**The Powerhouse Museum, Ultimo – Advice on Modification 1 – SSD-67588459**

Thank you for your correspondence dated 14 July 2025 inviting the City of Sydney (the City) to provide advice on the modification application for The Powerhouse Museum, Ultimo redevelopment.

**Figure 3 |** Wran Building / Galleria additional steel structure demolition works and glazing (Base source: Applicant’s modification)

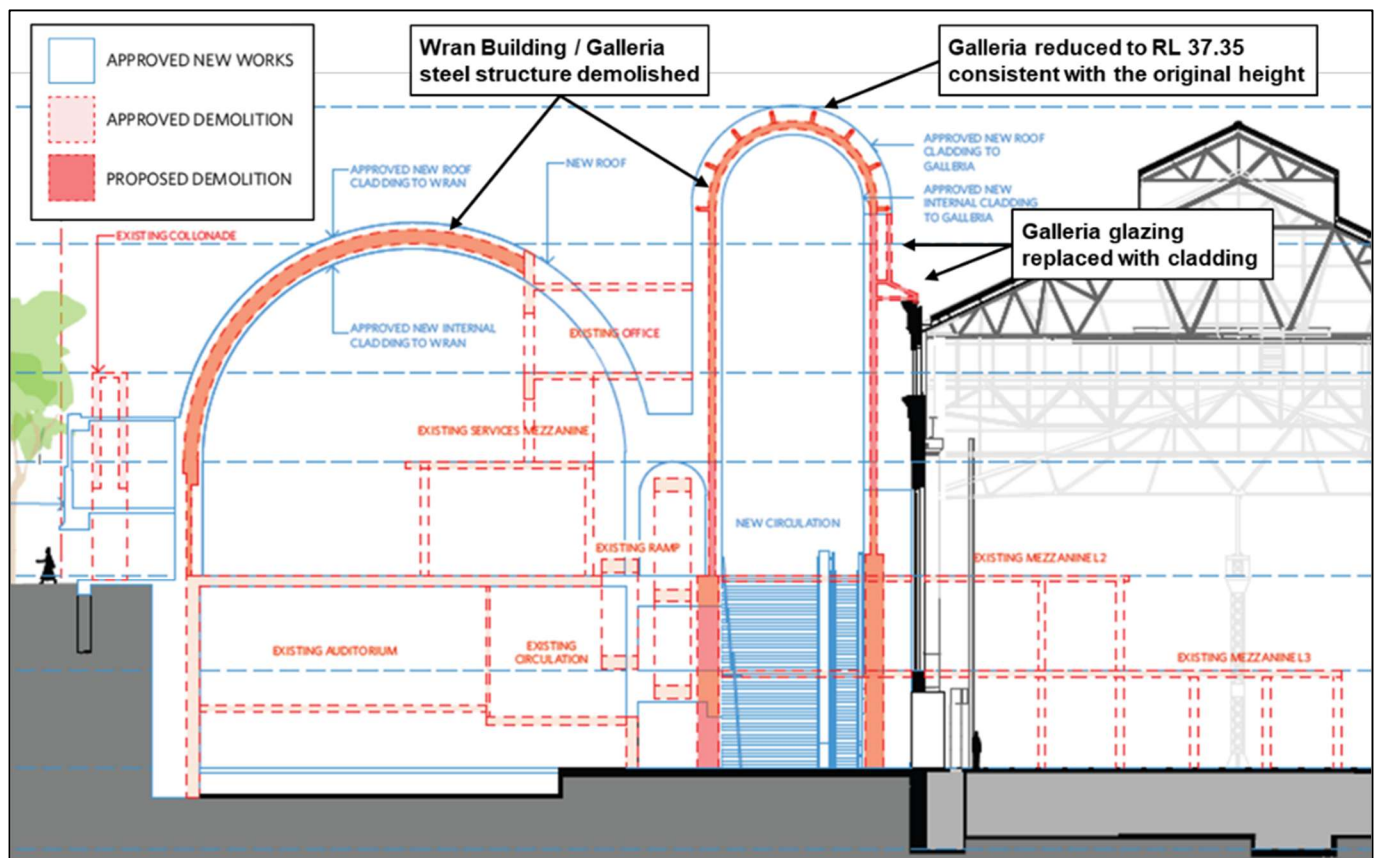
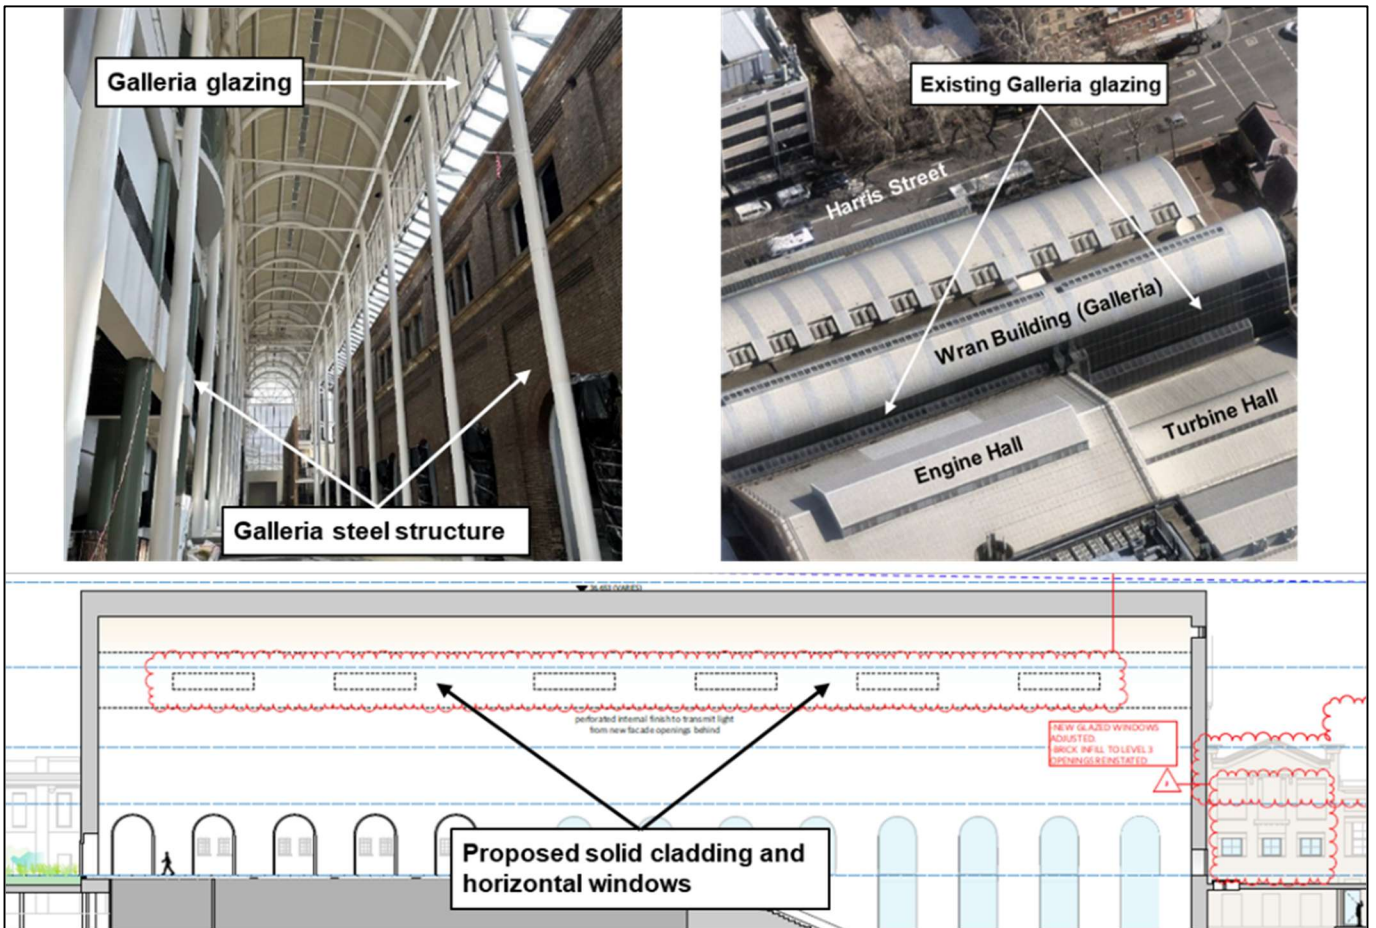
The now total demolition and reconstruction of the Wran Building and Galleria structure is disappointing and not supported. The modification comes after commitments were made to Council and the community about the Wran Building. The removal and replacement of the structure and fabric of the Wran Building and Galleria represents demolition of a substantial amount of building fabric associated with the 1980s redevelopment of the site and is considered to have a negative impact on the significance of the Powerhouse Museum complex and the ability to interpret the different phases of use over time. The structure should be retained and adaptively reused at a minimum.

More details should be provided to demonstrate the full extent of demolition and excavation works that will be required and how the new structures will be supported without damaging the existing footings of the adjacent building.

The retention or reconstruction of the Galleria and glazing should also be considered. The existing glazing provides a lighter and more spatial experience within the Galleria. The proposed replacement glazing is smaller in area and would result in a 'heavier and darker' experience. The glazing line would also provide maintain a clear visual break between the structures, delineating the existing heritage buildings and new buildings.
